From: [Les Stevens](#)
To: [A303 Sparkford To Ilchester](#)
Cc: [Les Stevens](#)
Subject: Deadline 5 Answers to ExA ExQ2
Date: 05 April 2019 15:03:12
Attachments: [PINS ExQ2 - Parish Councils" Joint Response Final 05 04 19.pdf](#)

Joint Feedback from Queen Camel, West Camel and Sparkford Parish Councils to PINS Written Questions (ExQ2)

FIGURE 2.5  
HAZLEGROVE JUNCTION UNDERBRIDGE  
GENERAL ARRANGEMENT

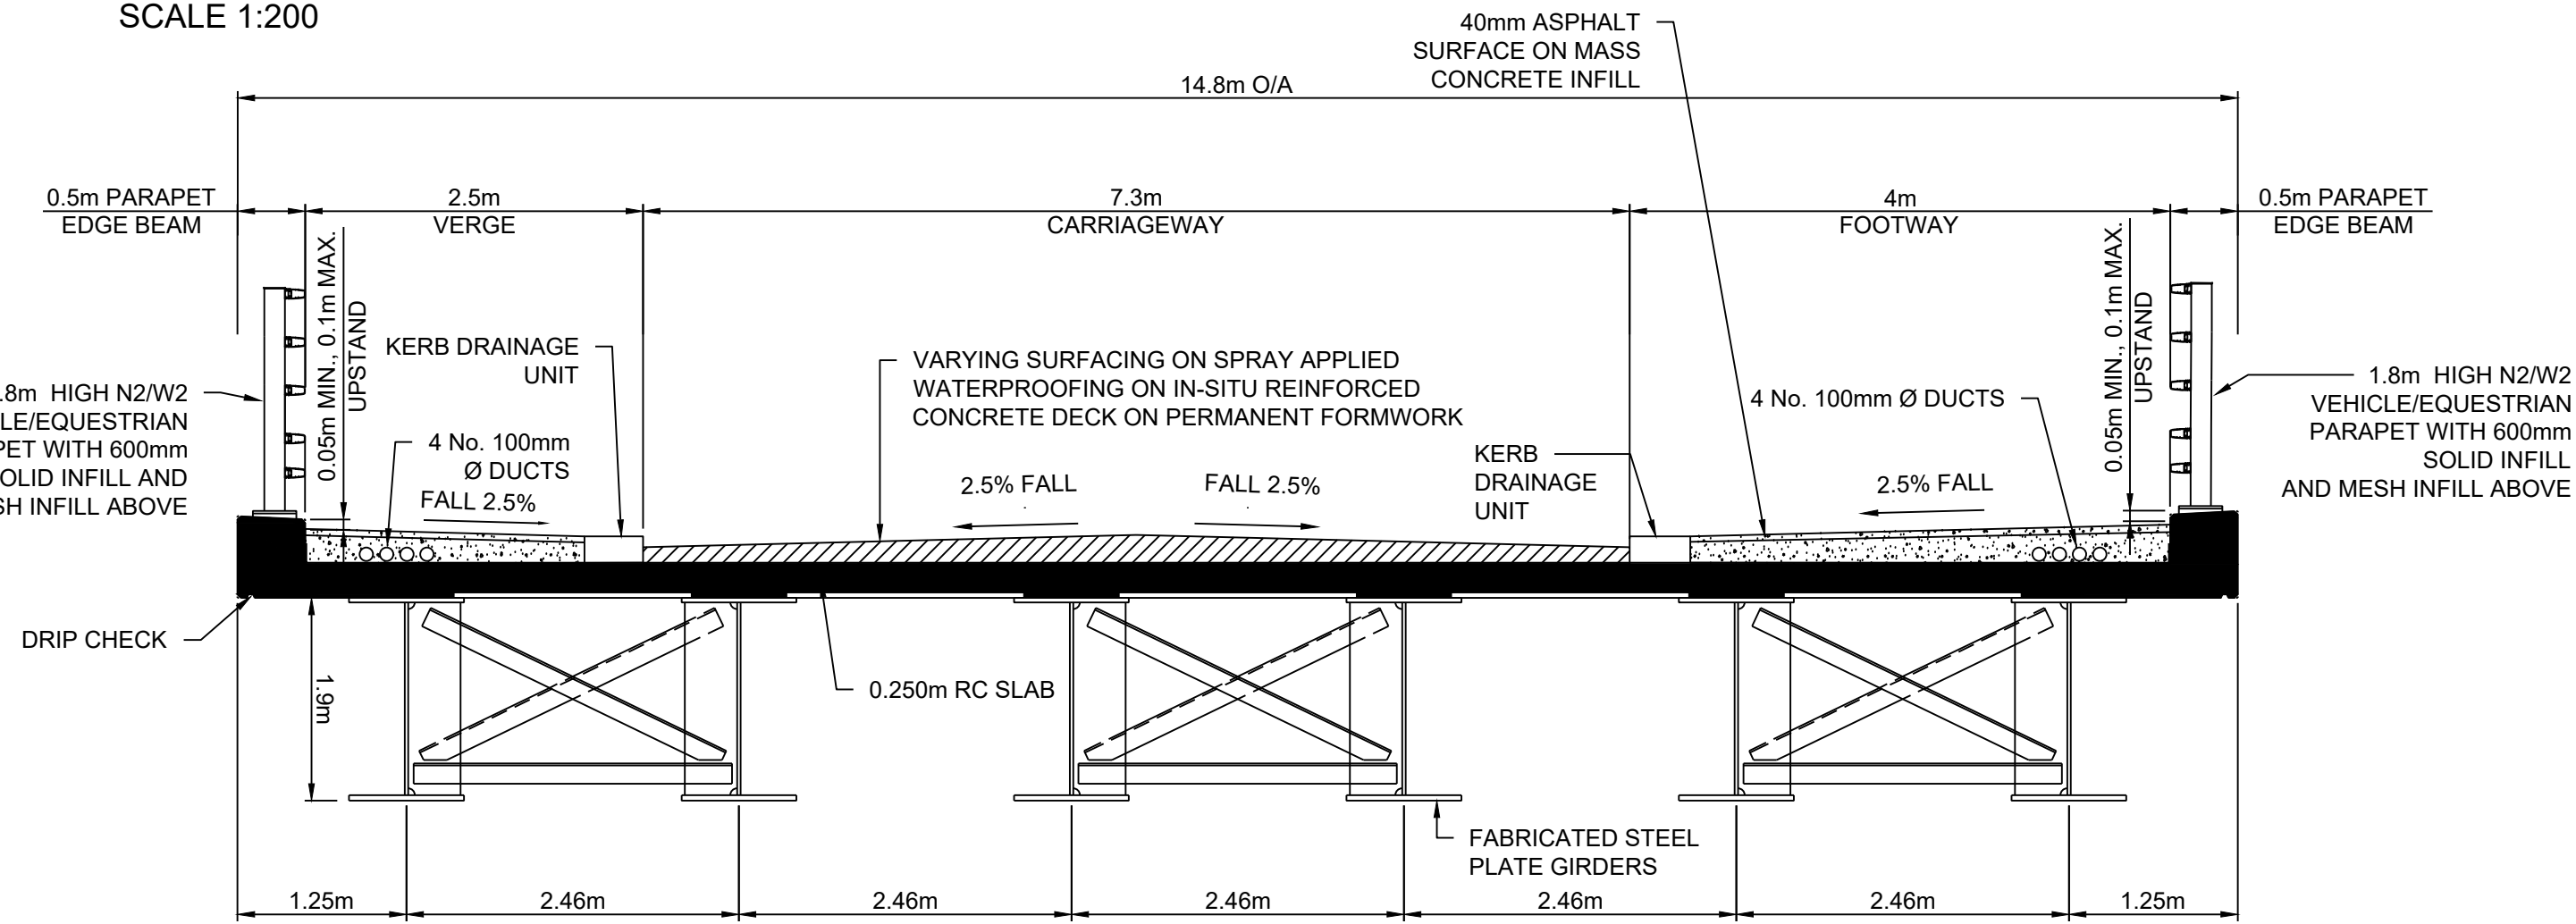
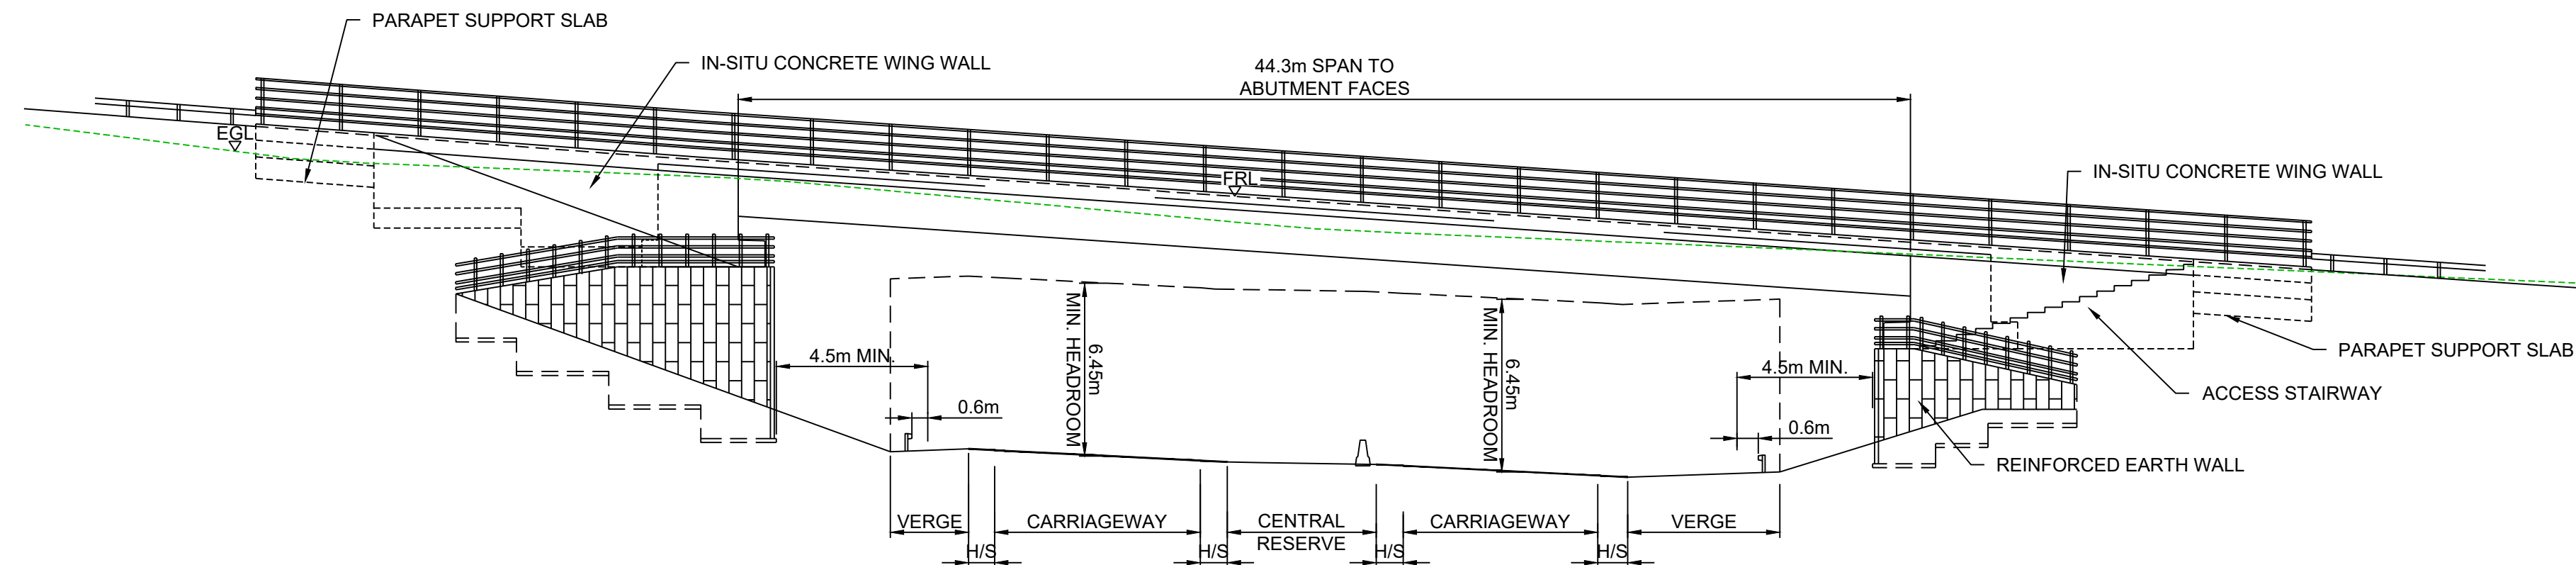
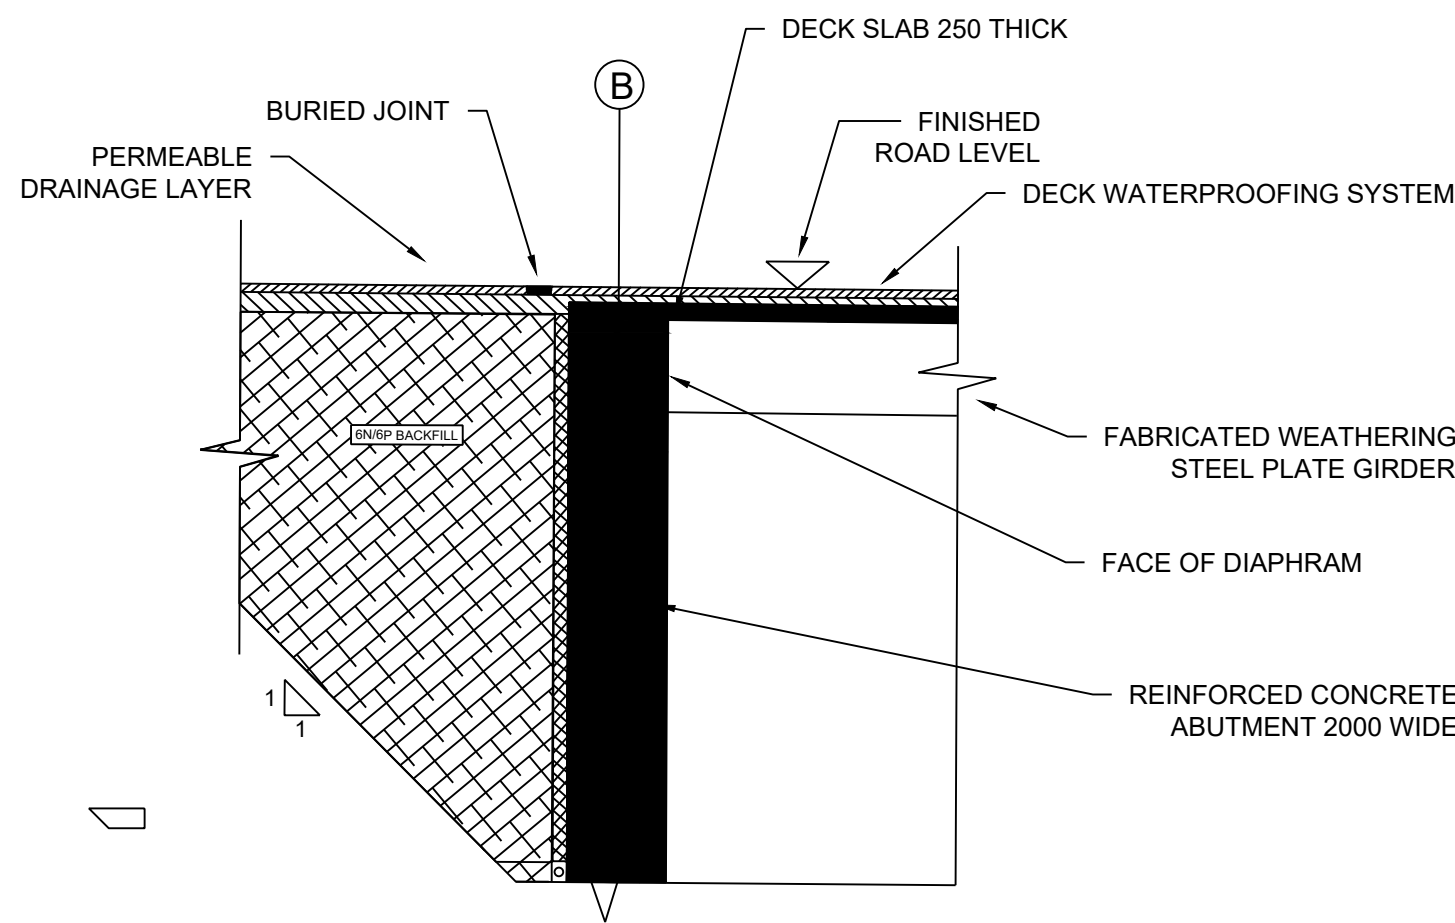
2.6.6	The Applicant	Hazlegrove Underbridge	Comment – Parish Council proposals separate NMU and slow moving Agricultural traffic through a separate short underbridge providing a much improved level of safety for all road users and horses in particular.
